An
Coimisiún
Pleanála

Commission Order
ABP-320327-24

Planning Authority: Wicklow County Council

Planning Register Reference Number: EX53/2024

1 01.00 Ground Floor
1 : 100

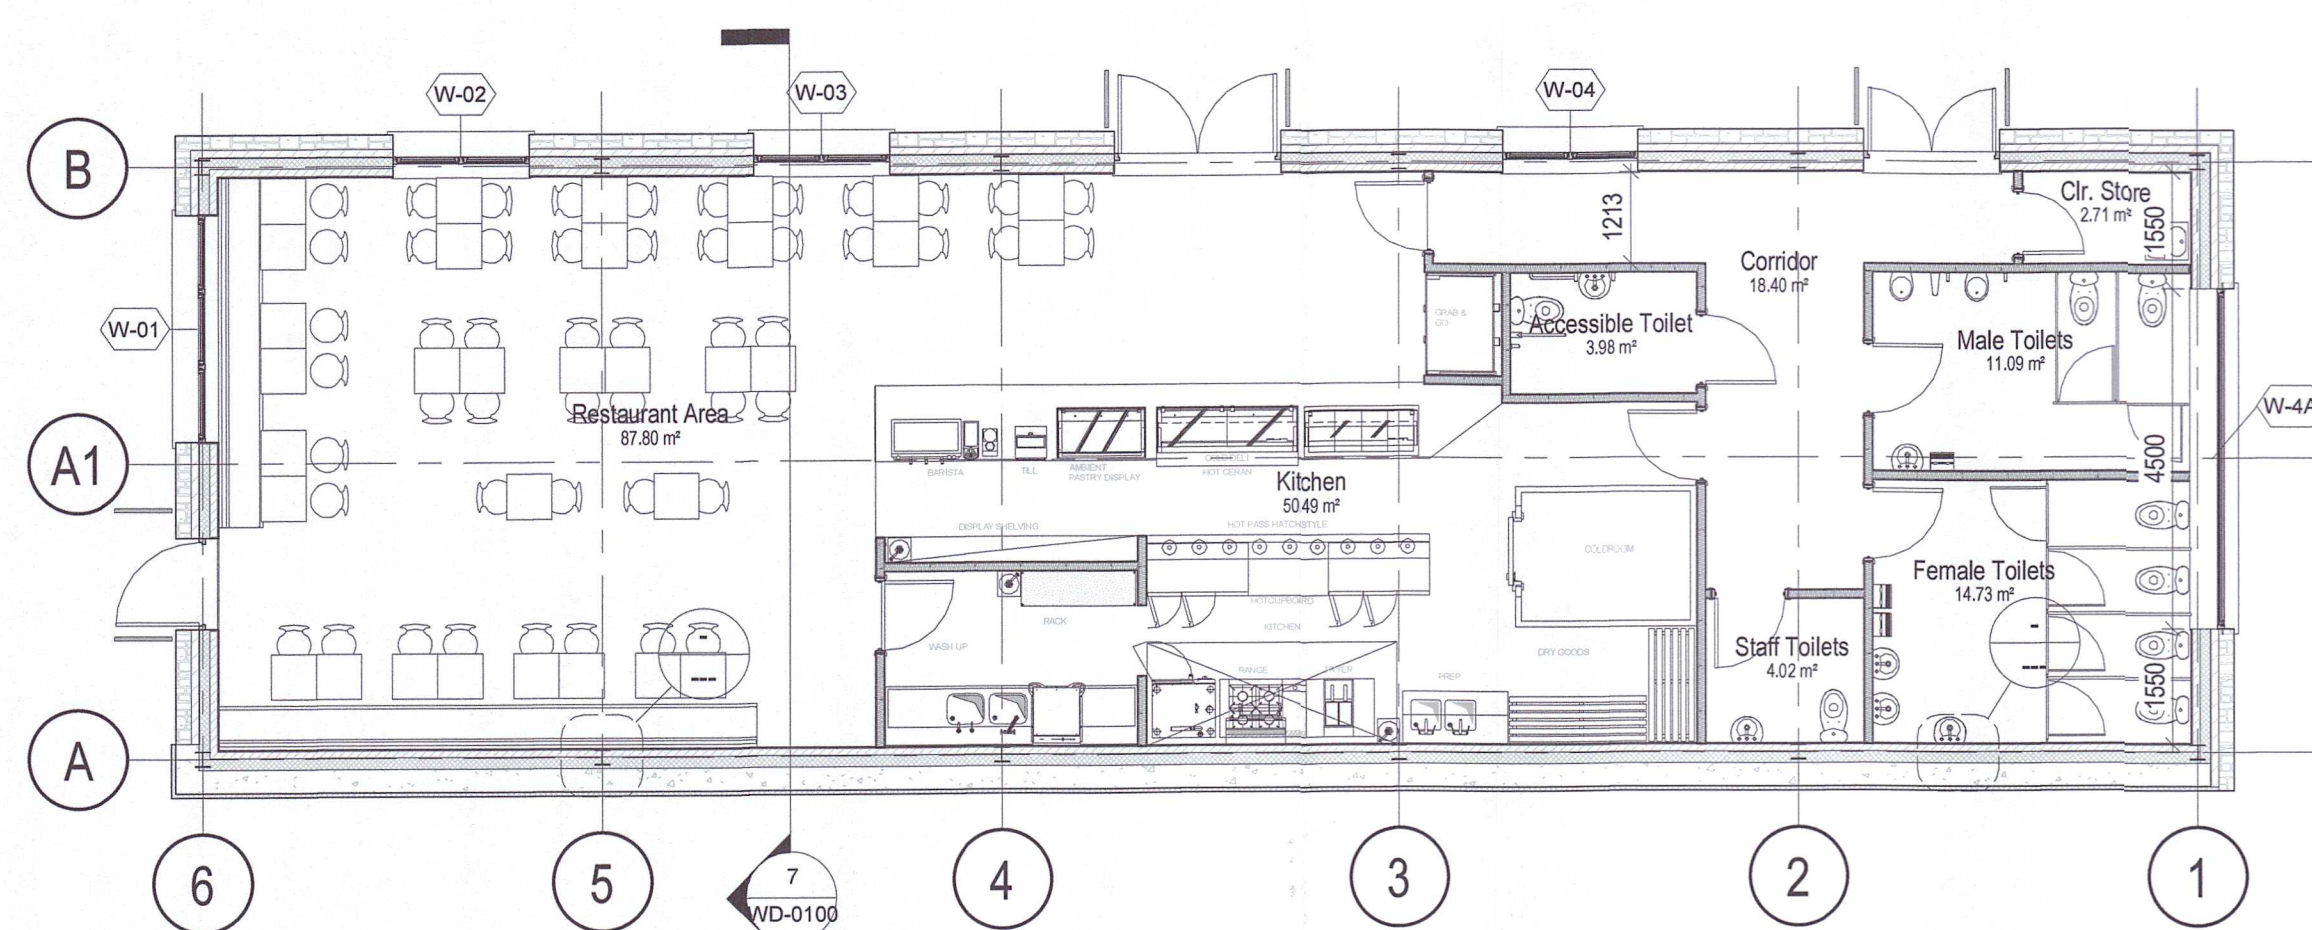
- (g) Structure Number 7 and Structure Number 8: The construction of the pavilion and kitchen buildings do not come within the scope of Section 4(1)(h) of the Planning and Development Act 2000, as amended, as they are new structures. Therefore, these structures do not constitute exempted development.
- (h) Structure Number 10: Having regard to the significant nature and scale of the works to the original structure 'Belfry' and the development approved under planning authority Register Reference 05/2792 the works do come within the scope of Section 4(1)(h) of the Planning and Development Act, 2000, as the works materially affects the external appearance of the structure so as to render its appearance inconsistent with the character of the structure. Therefore, the works do not constitute exempted development.

Structure 12 - Plans,
Elevations & Section

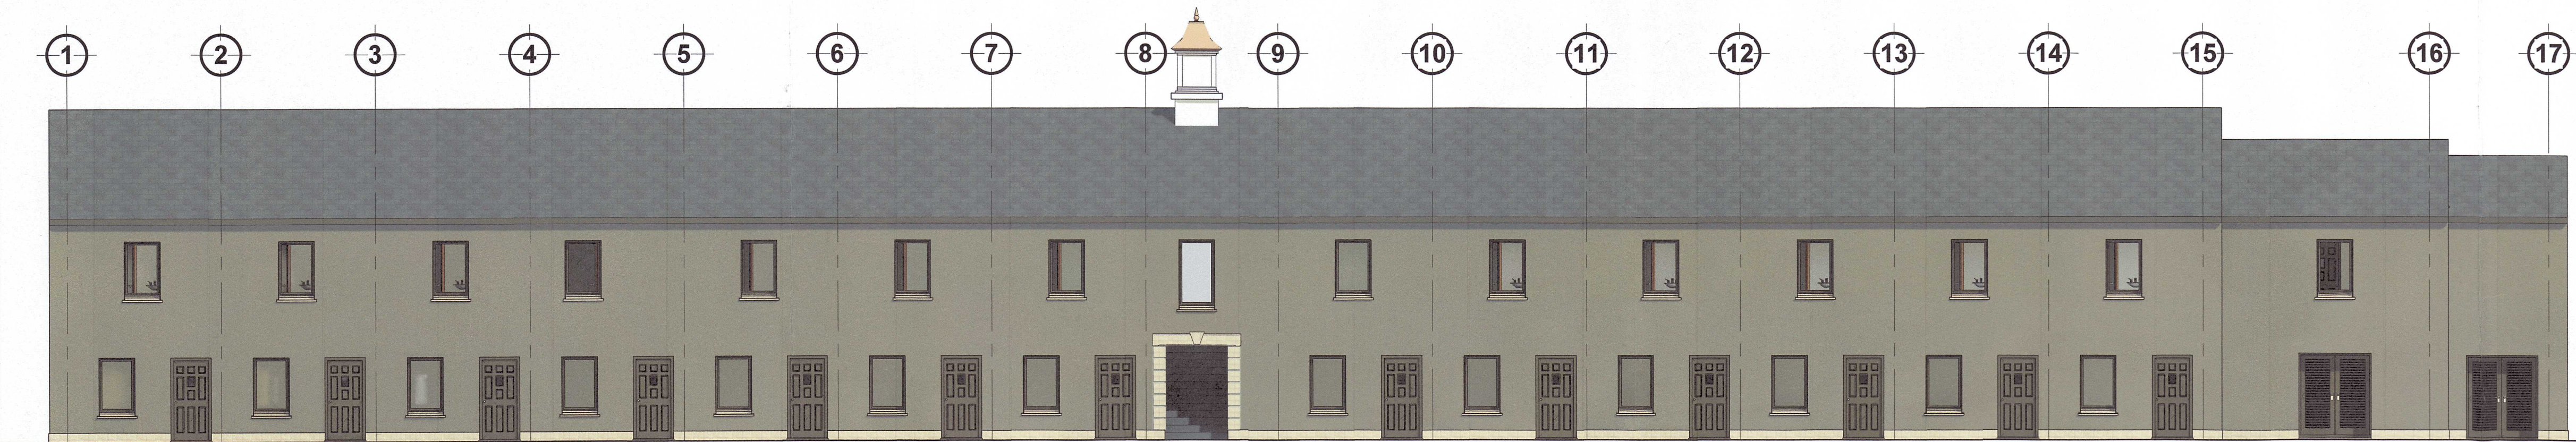
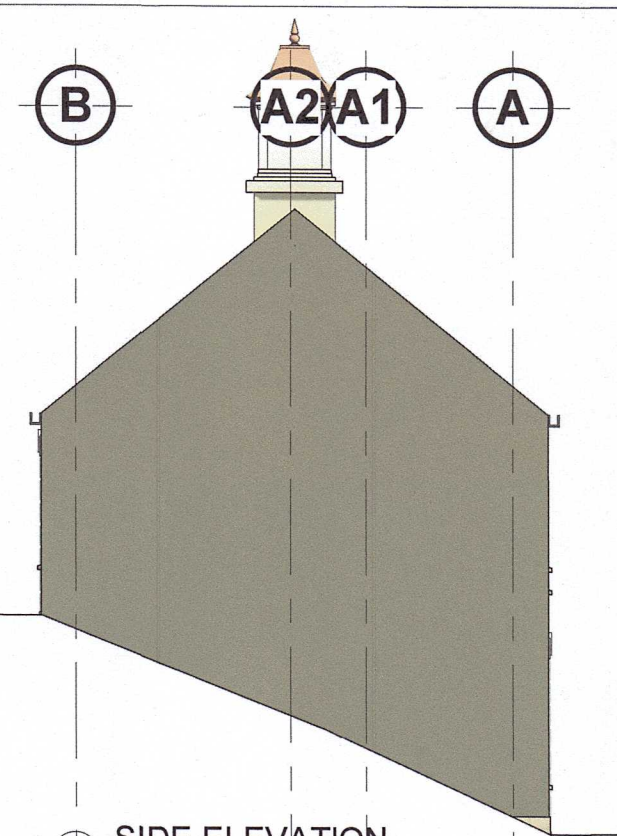
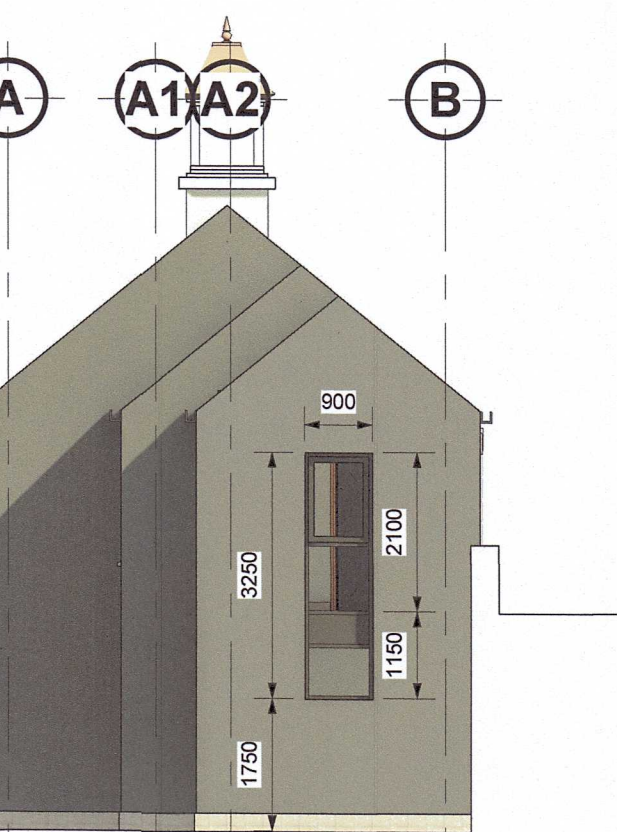
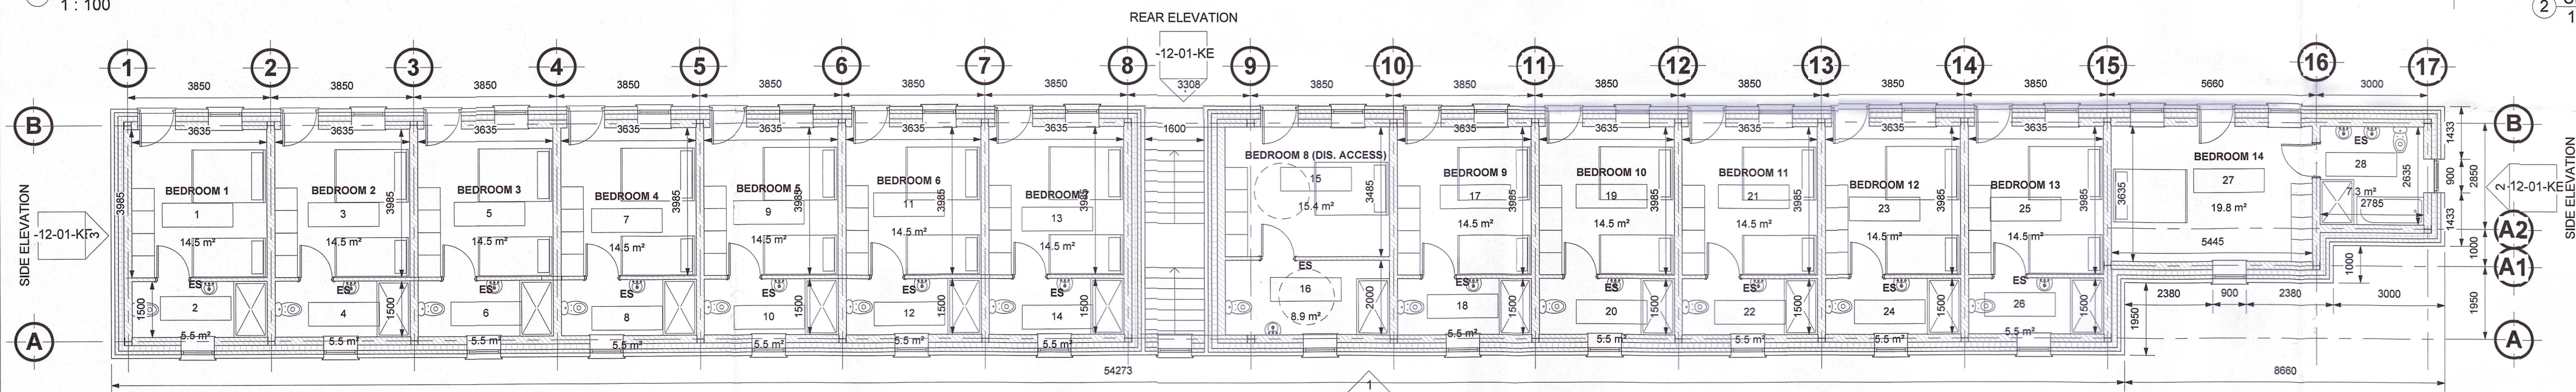
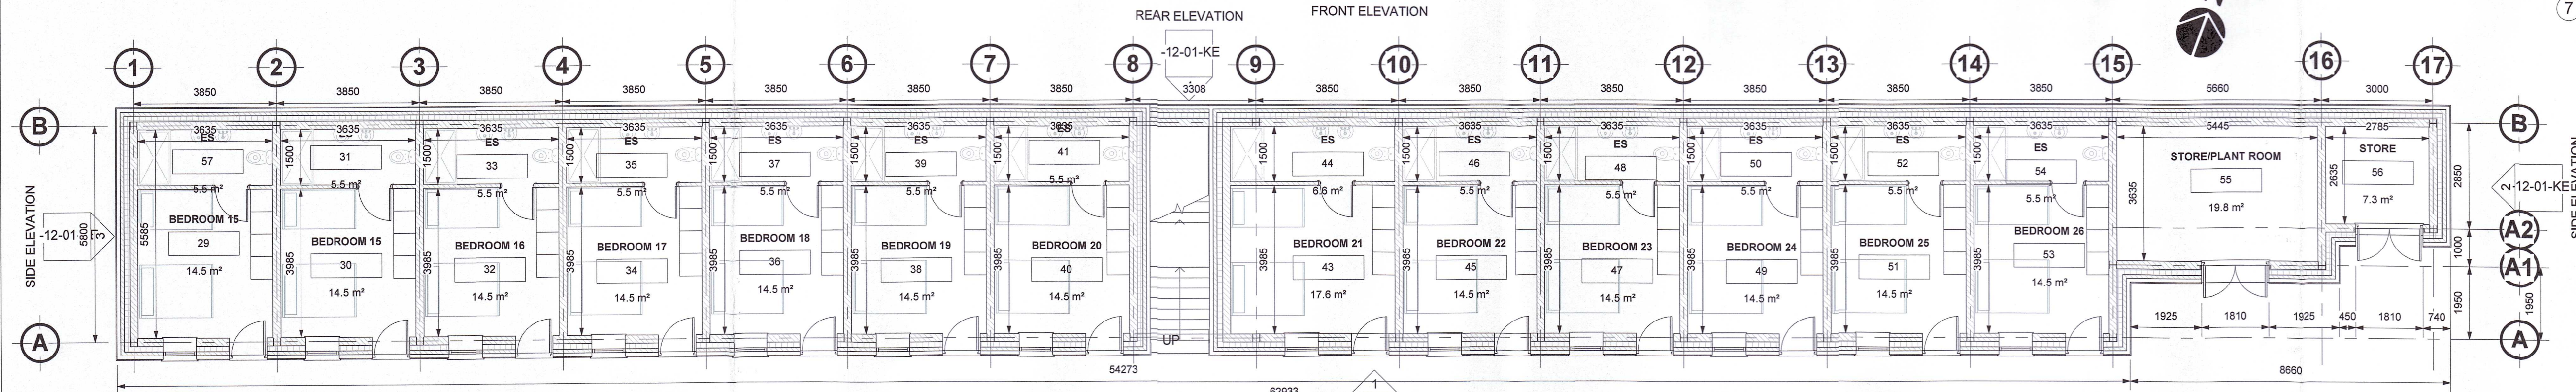
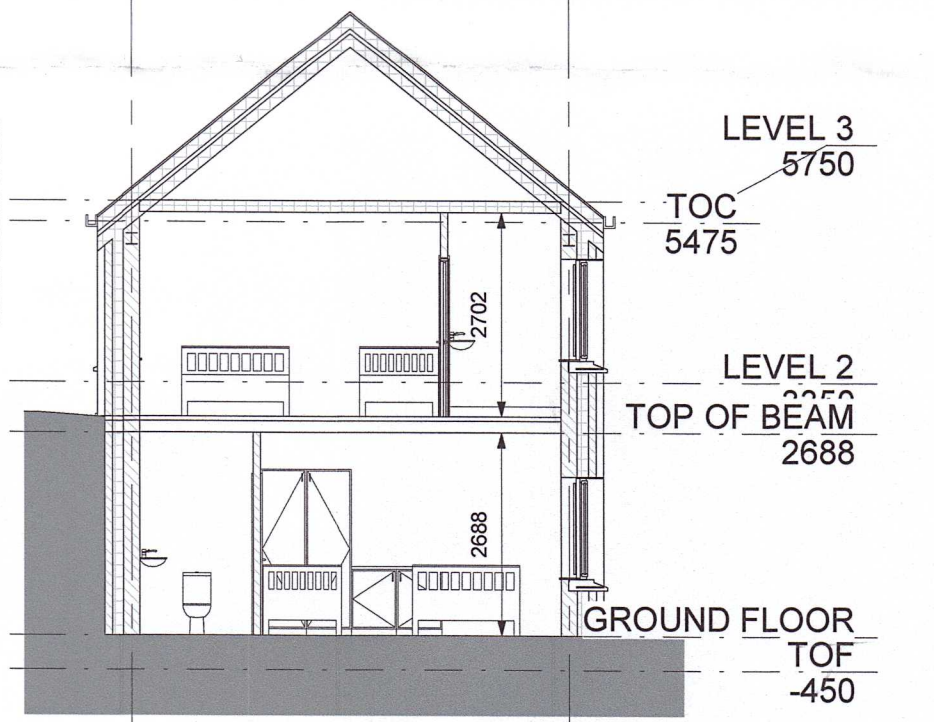
- (j) Structure Number 12: Accommodation block does not come within the scope of Section 4(1)(h) of the Planning and Development Act 2000, as amended, as it is a new structure. The construction of Structure Number 12 does not fall within the scope of Class 14(h), (i) or (j), of Part 1 of Schedule 2 of the Planning and Development Regulations 2001, as amended, as the development does not comprise a change of use. The construction of Structure Number 12 does not fall within the scope of Class 20F of Part 1 of Schedule 2 of the Planning and Development Regulations 2001, as amended, as the development does not comprise a change of use. There is no evidence that Structure Number 12 was carried out in accordance with the provisions of the European Union (Planning and Development) (Displaced Persons from Ukraine Temporary Protection) Regulations 2022 (S.I. Number 306/2022). There is no evidence that the structure is related to accommodation for displaced persons, given the definition of such persons as set out in Annex 2 of the Council Implementing Decision (EU) 2022/382. Therefore, the structure does not constitute exempted development.

JOB TITLE	Development at Kippure Estate	
CLIENT	Tondo Ltd.	DATE
LOCATION	Manor Kilbride, Blessington, Co. Wicklow.	14/02/24
SDSUS	APPROVED	SCALE
DRAWN	APPROVED	1:100 @ A3
BORNING No.	Structure No. 1	REVISION
PL1081KE	Gate Lodge A.

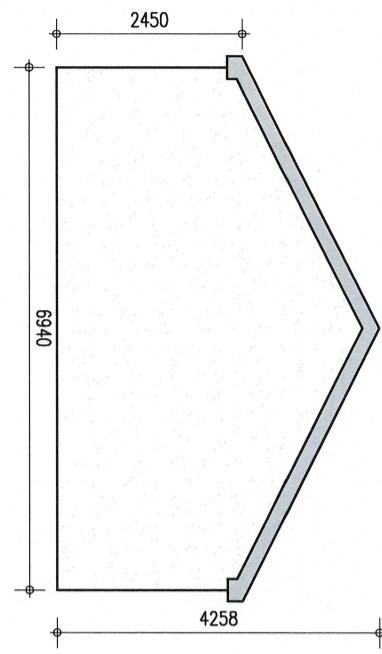
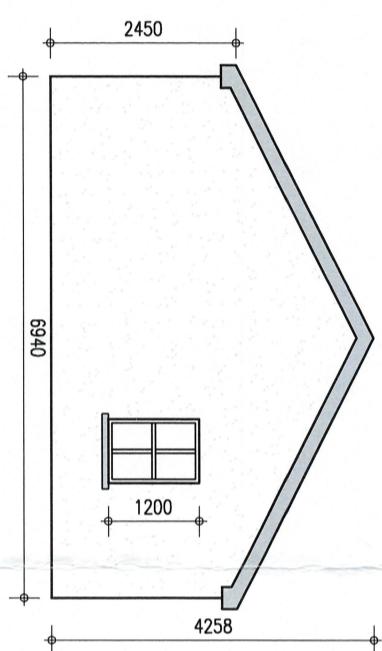
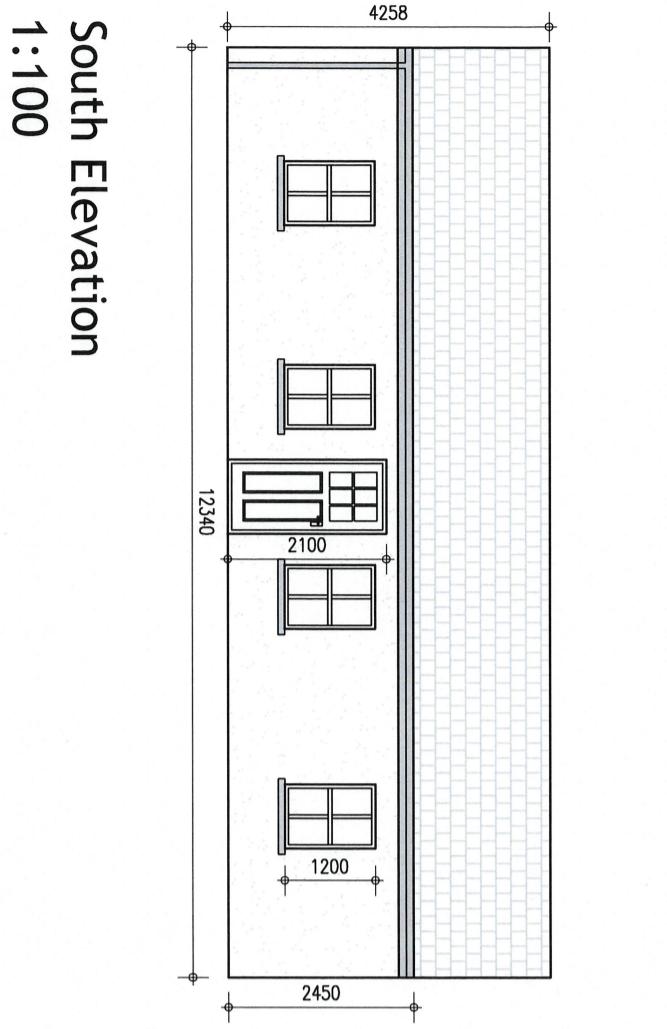
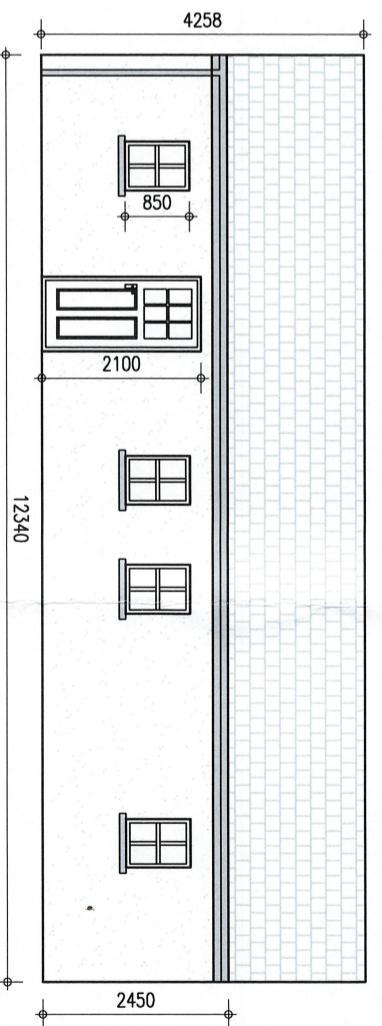
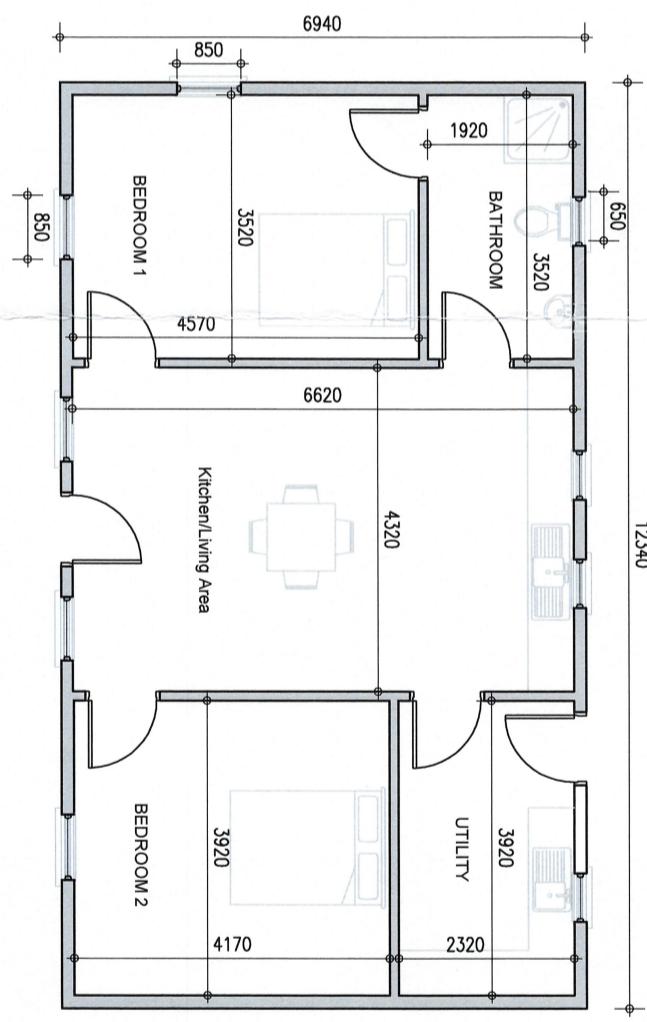
- (a) Structure Number 1: Gate Lodge A and Gate Lodge B do not come within the scope of Section 4(1)(h) of the Planning and Development Act 2000, as amended, as they are new structures. These structures do not fall within the scope of Class 17 of Part 1 of Schedule 2 of the Planning and Development Regulations 2001, as amended, as they are to provide accommodation for security staff for persons occupying the facility during its operational phase and do not relate to accommodation for persons employed or otherwise during construction works. Therefore, these structures do not constitute exempted development.
